**Consultation Response from KC,
Highways Development Management**

**2023/93576 land to the east of Robledo, Beaumont Park Road, Beaumont Park, Huddersfield,
HD4 5JT**

Erection of detached dwelling

Date Responded: 14/08/2024.

Appendix 3: Proposed Development Plan

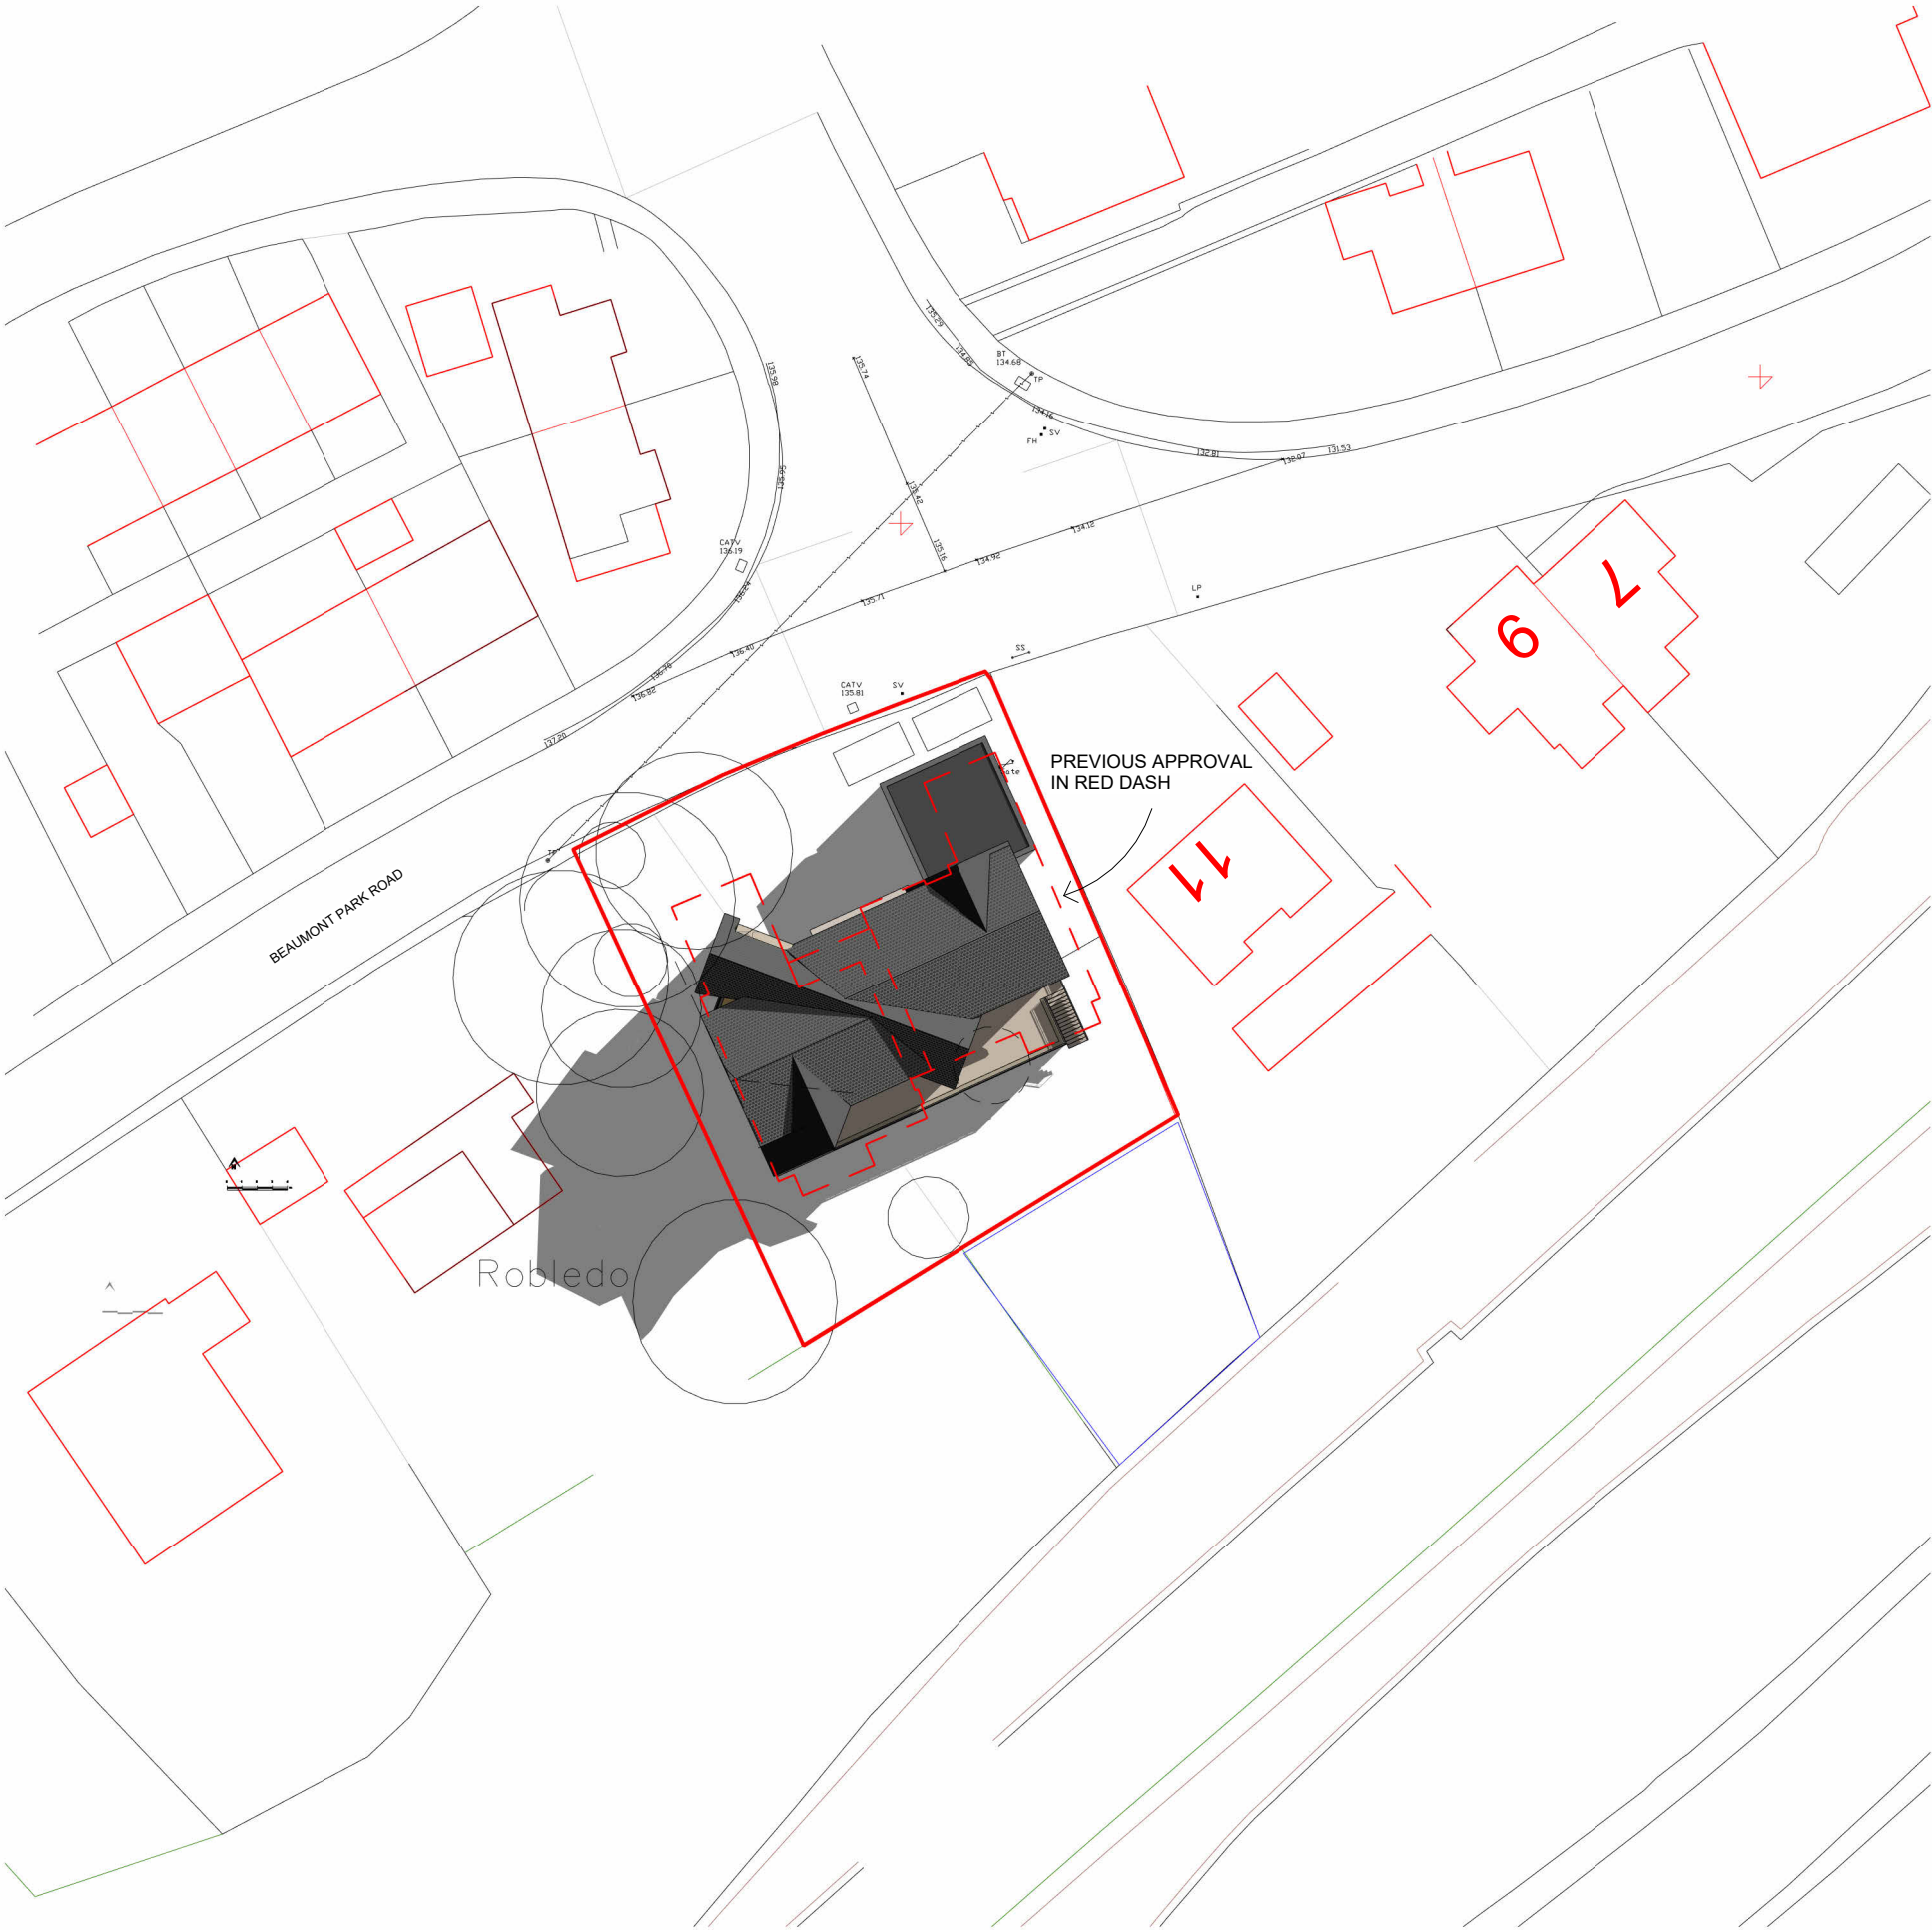
The proposed access uses the same access as that previously approved and is acceptable.

The proposal has provided for a minimum of three parking spaces which meets the local guidance for vehicle parking, together with a turning area for vehicles to enter and leave the site in forward gear

No Bin storage areas are shown. A bin storage area needs to be provided and a bin collection/presentation point should be located adjacent to the public highway.

Details of waste storage and collection for both dwellings should be provided, with the location of a waste collection presentation point being clearly marked on a drawing in such a location that is easily accessible to the collection team and where it will not obstruct the parking, access, or the adopted highway for road safety reasons.
